WEST SUSSEX COUNTY COUNCIL CONSULTATION

TO:	Arun District Council FAO: Mr S Davis
FROM:	WSCC – Highways Authority
DATE:	30 March 2026
LOCATION:	Land East of Heath Place Bersted PO22 9SL
SUBJECT:	BE/15/26/PL Erection of a 3-storey building comprising of under-croft car parking and bicycle store, 2 floors of 4 No self-contained flats on each (8 No flats in total) with pedestrian access formed onto Ash Grove. This application is in CIL Zone 4 (Zero Rated) as flats.
DATE OF SITE VISIT:	n/a
RECOMMENDATION:	No Objection

Proposed Site Plan
1:200

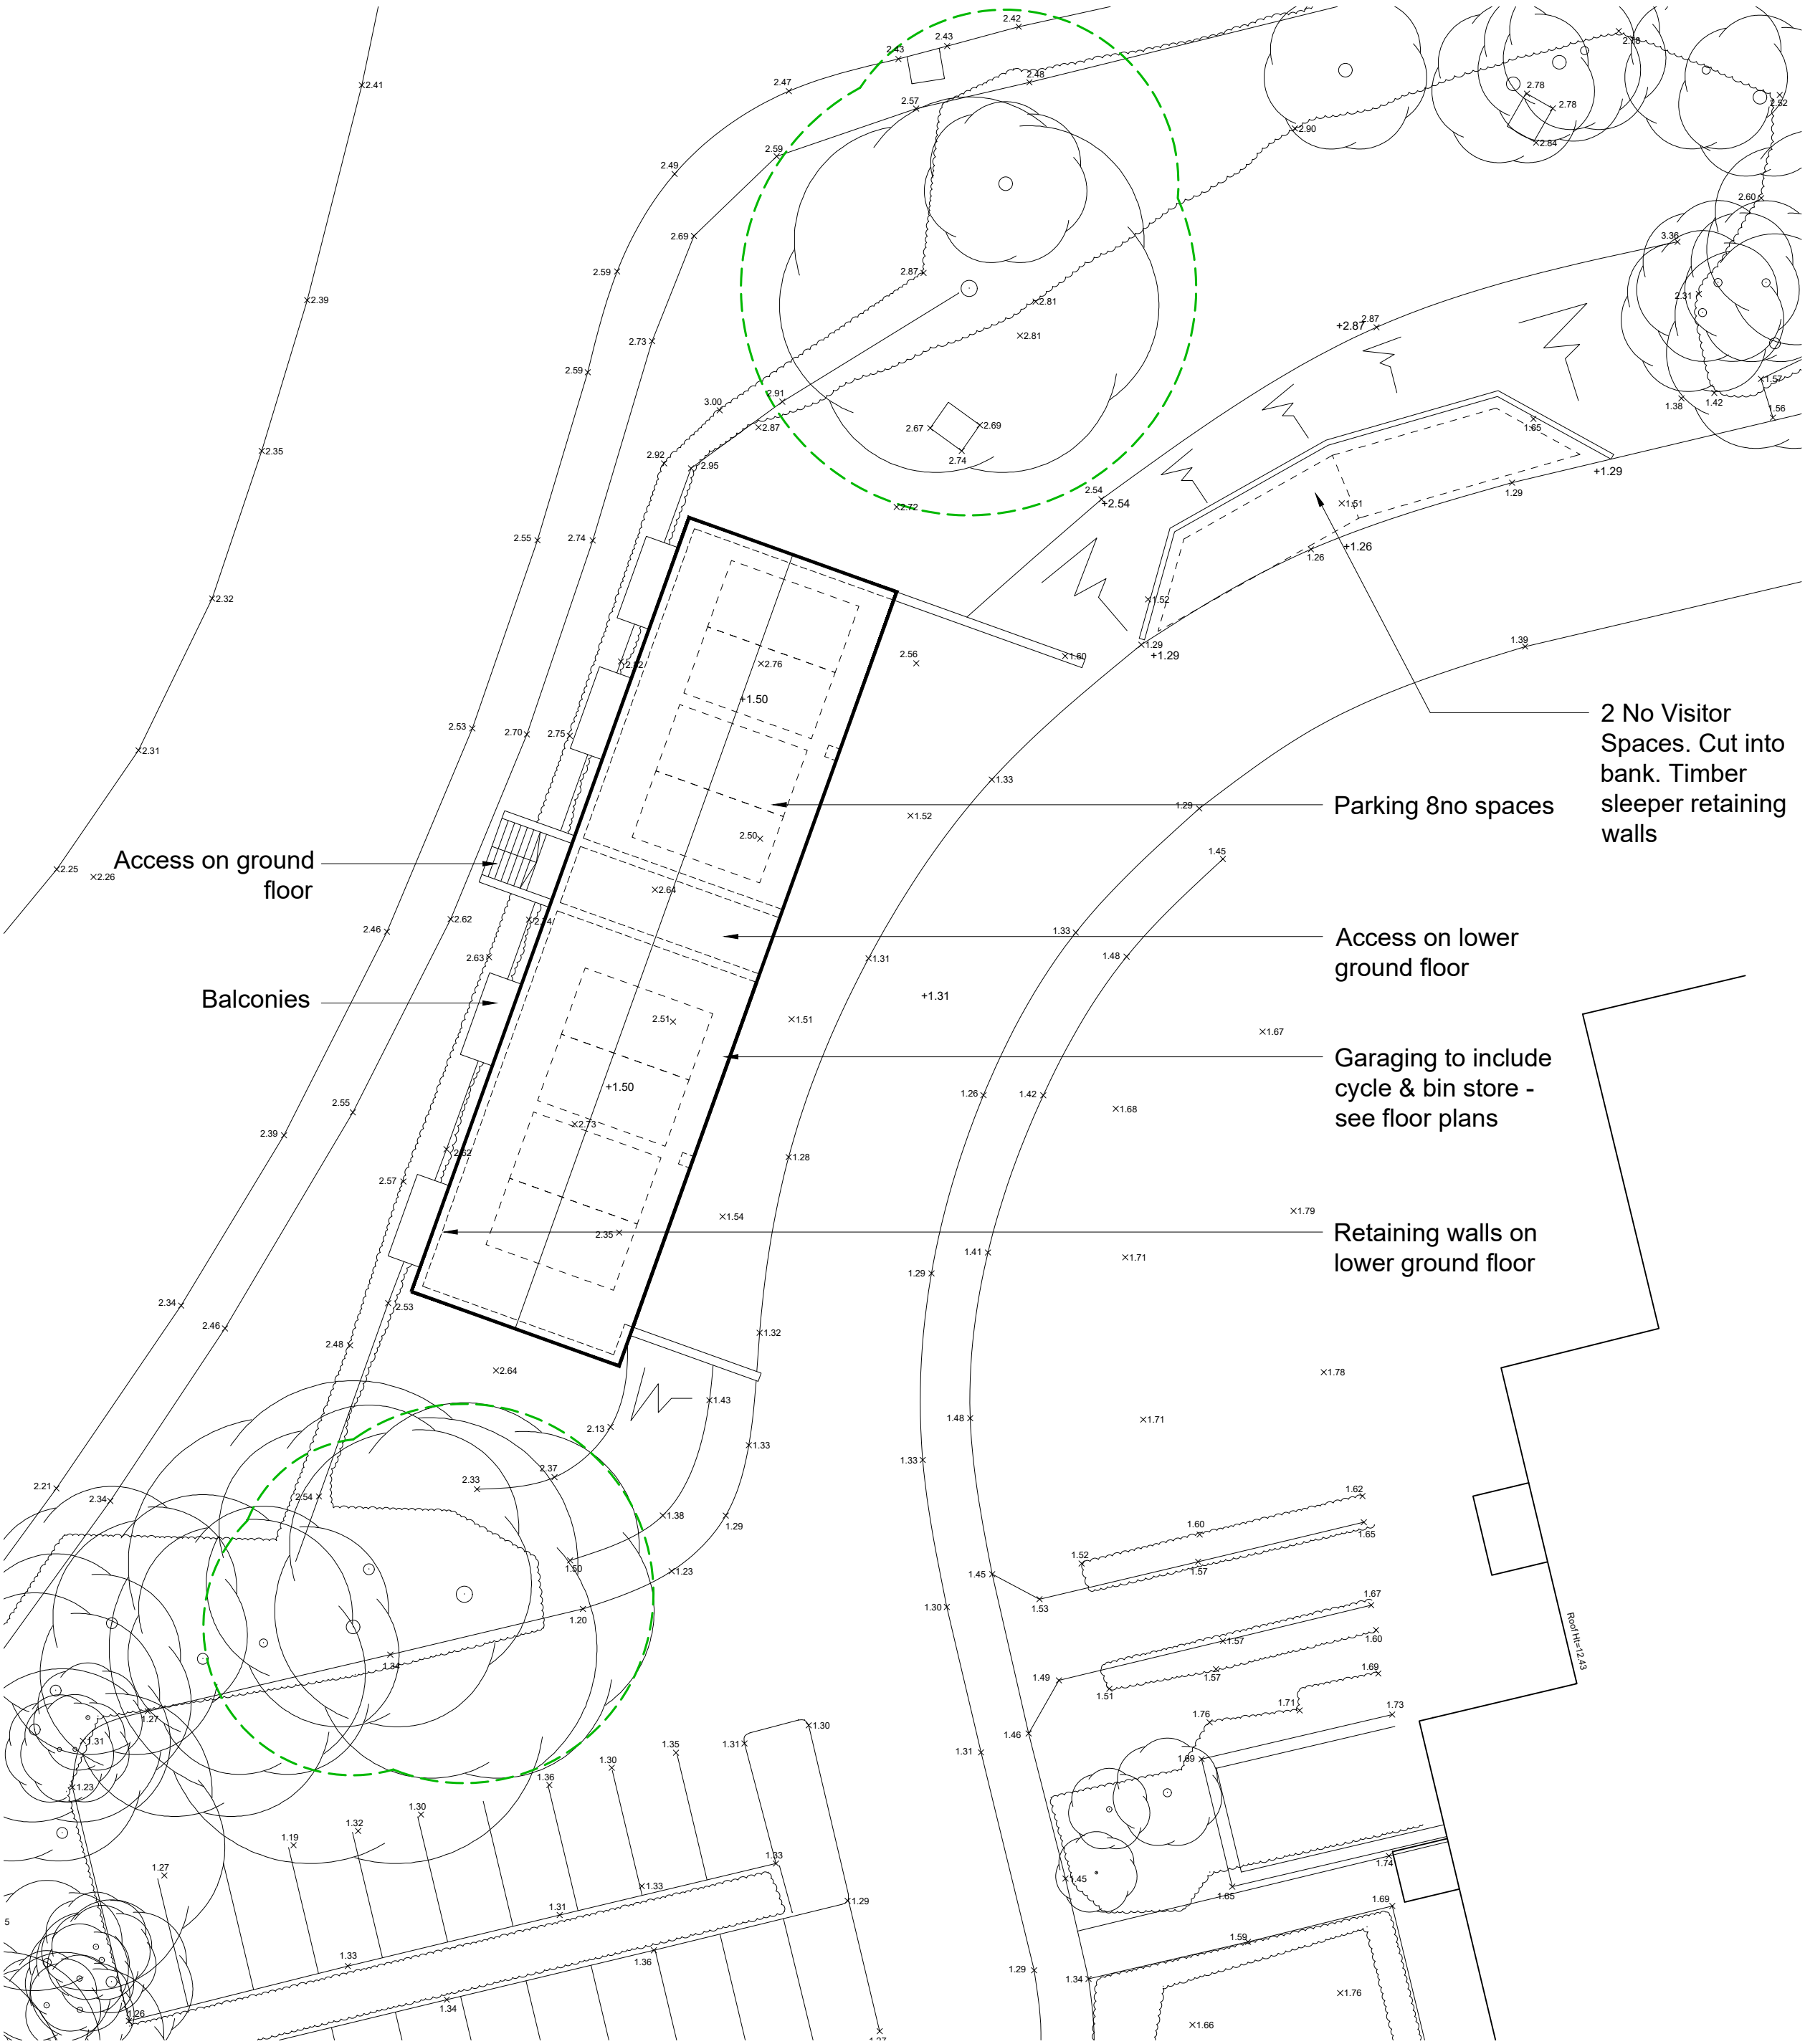
The Highway Authority advise the provision of dropped kerb and tactile paving along both sides of Ash Grove near to the pedestrian access for safe pedestrian crossing.

The flats will provide 1 car parking space per dwelling. Each parking space will be created with the dimensions 6 x 3m and include a cycle parking space for each flat in dedicated stores in the undercroft parking area. Whilst this number of parking spaces is below the recommended number of 2 spaces per flat, in the WSCC car parking guidance document, given the site's location and number of bedrooms it would be considered acceptable to reduce this.

However, visitor parking should still be offered at 0.2 spaces per dwelling. This would equate to 2 spaces (rounded up). Since this type of parking would be in demand on evenings and at weekends, there would likely be parking available for visitors in the Heath Place car park, or within the access road.
